Re: Bayside Council Submission: Eden Street, Arncliffe Mixed Use Redevelopment

STATE SIGNIFICANT DEVELOPMENT EDEN STREET ARNCLIFFE REDEVELOPMENT

SUBMISSION

NORTH

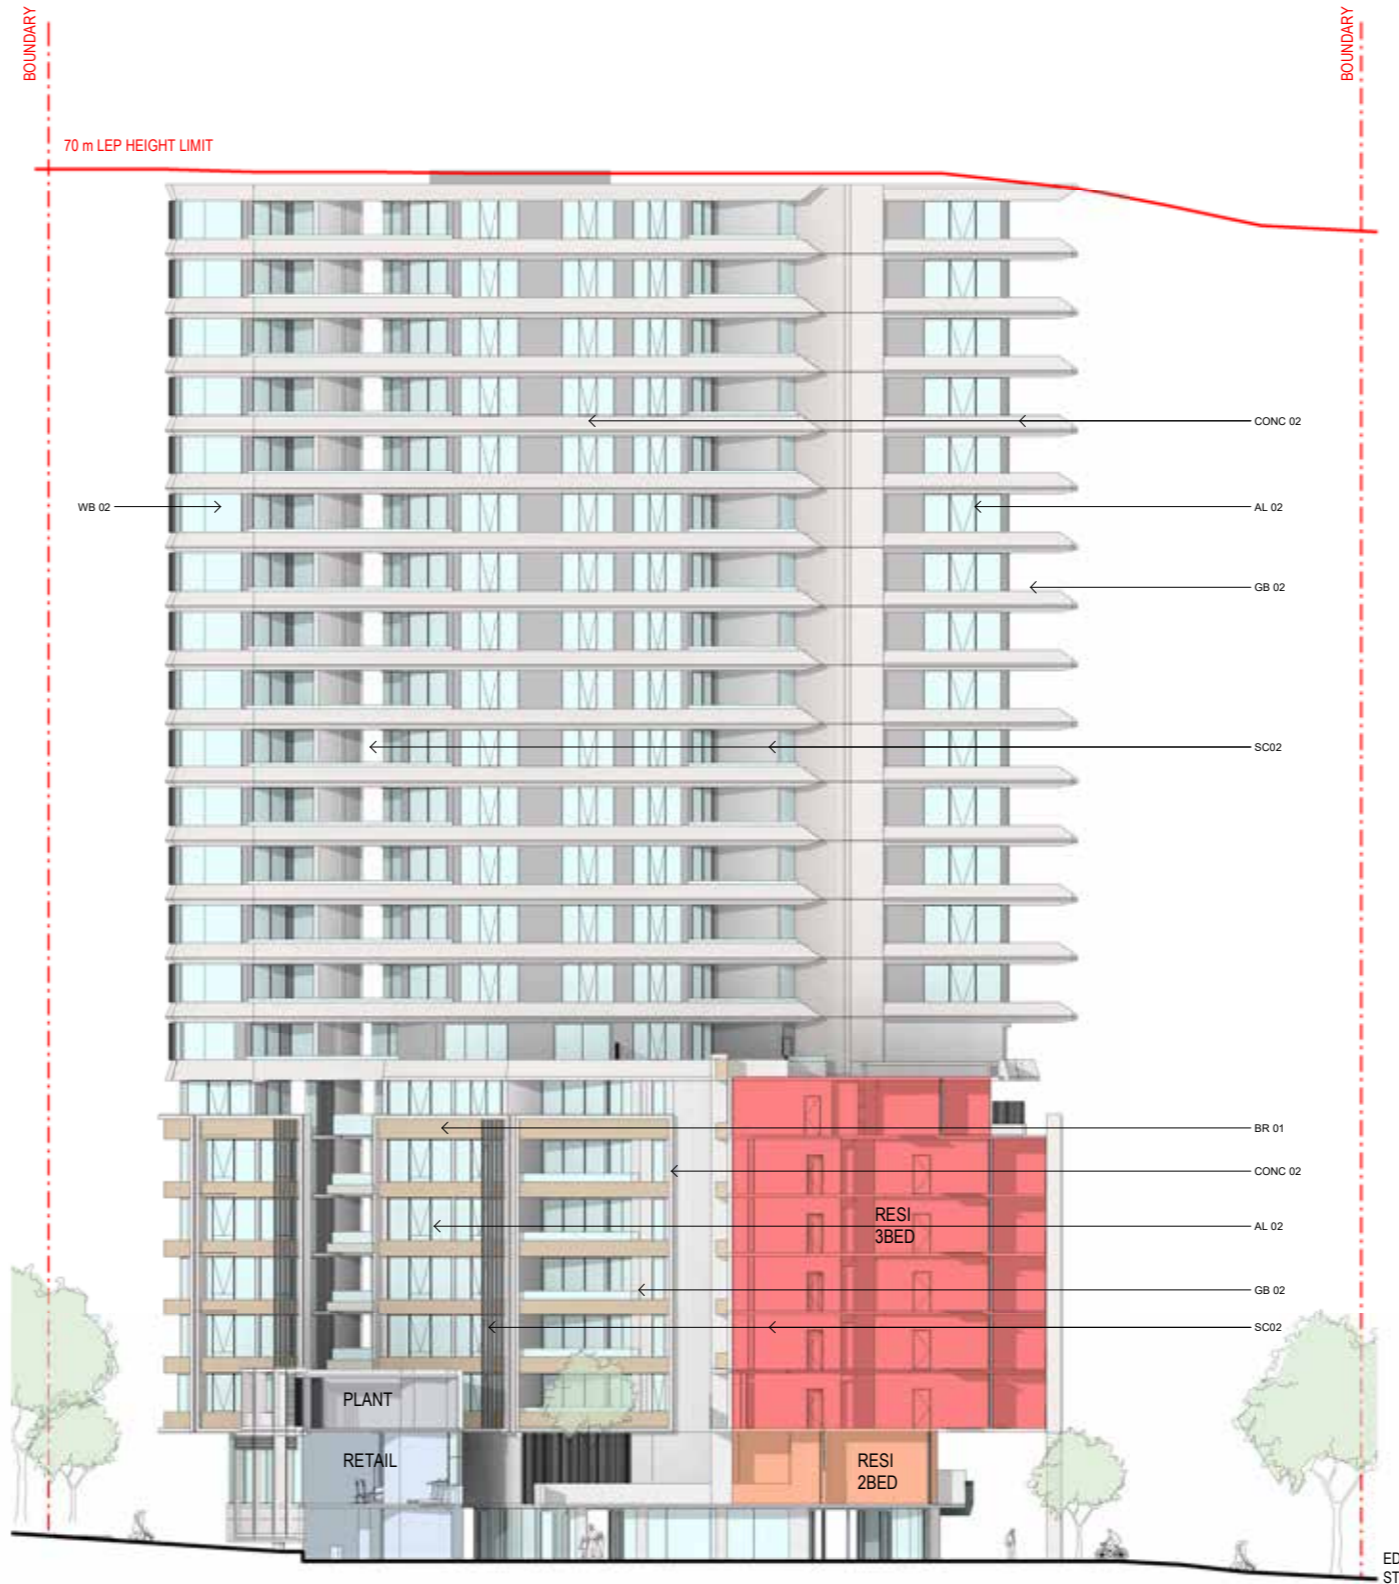
The commentary of the surrounding heights, and the proposal's 'transition' to them, is questionable. As stated above, the height differential is dramatic and not considered transitional. Further, there is no attempt to setback the additional height from the edges of the building, especially where the entirety is set against the street wall height of the Princes Highway elevations. This is not supported.

There is no attempt to setback the additional height from the edges of the building, especially where the entirety is set against the street wall height of the Princes Highway elevations. This is not supported.

Deep Soil + Natural Ground = 13% of site area

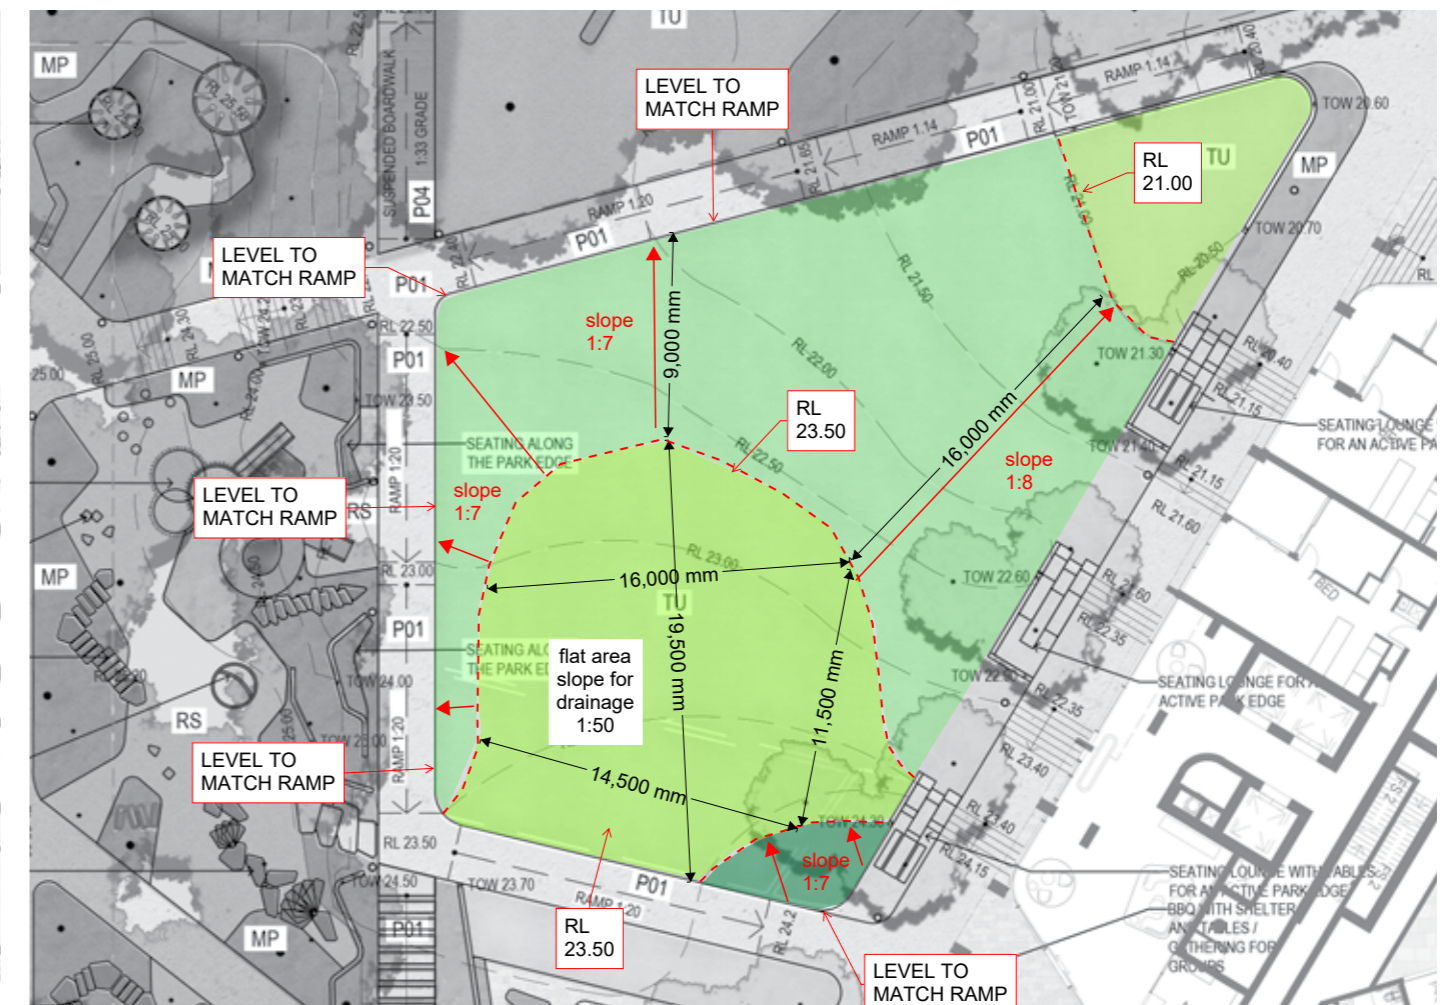
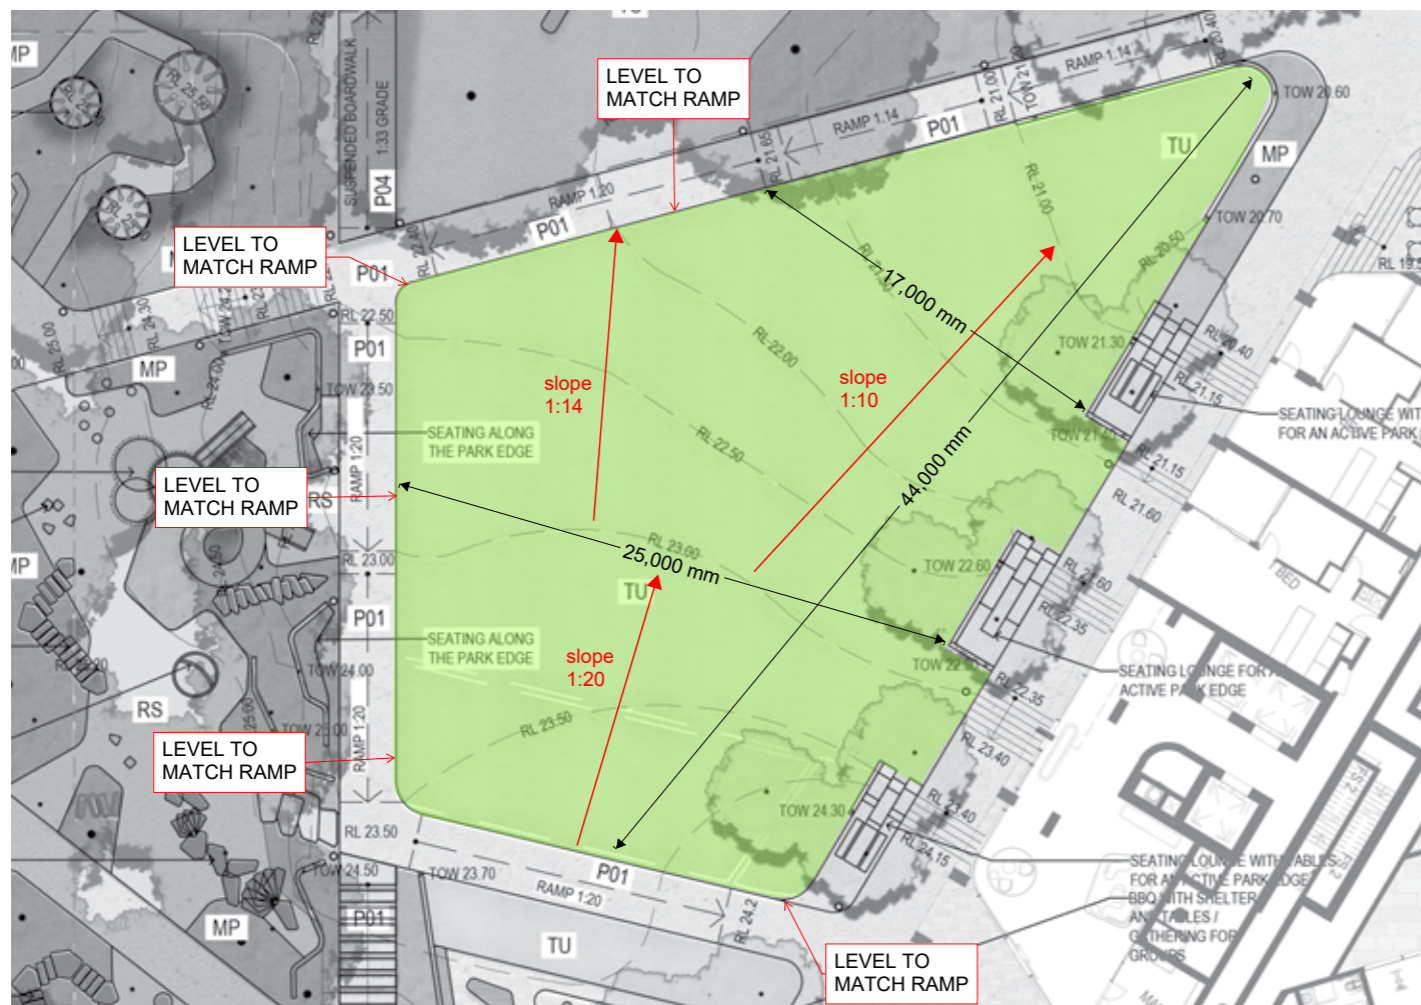
For sites that have an overall area greater than 1,500sqm, Part 3E of the ADG recommends that 15% deep soil with a minimum dimension of 6 metres be provided. At 7%, the proposal is substantially below and would benefit from additional deep soil provided along the Princes Highway frontage to allow for large tree planting. This will require a greater basement setback and may potentially result in the loss of several carparking spaces.
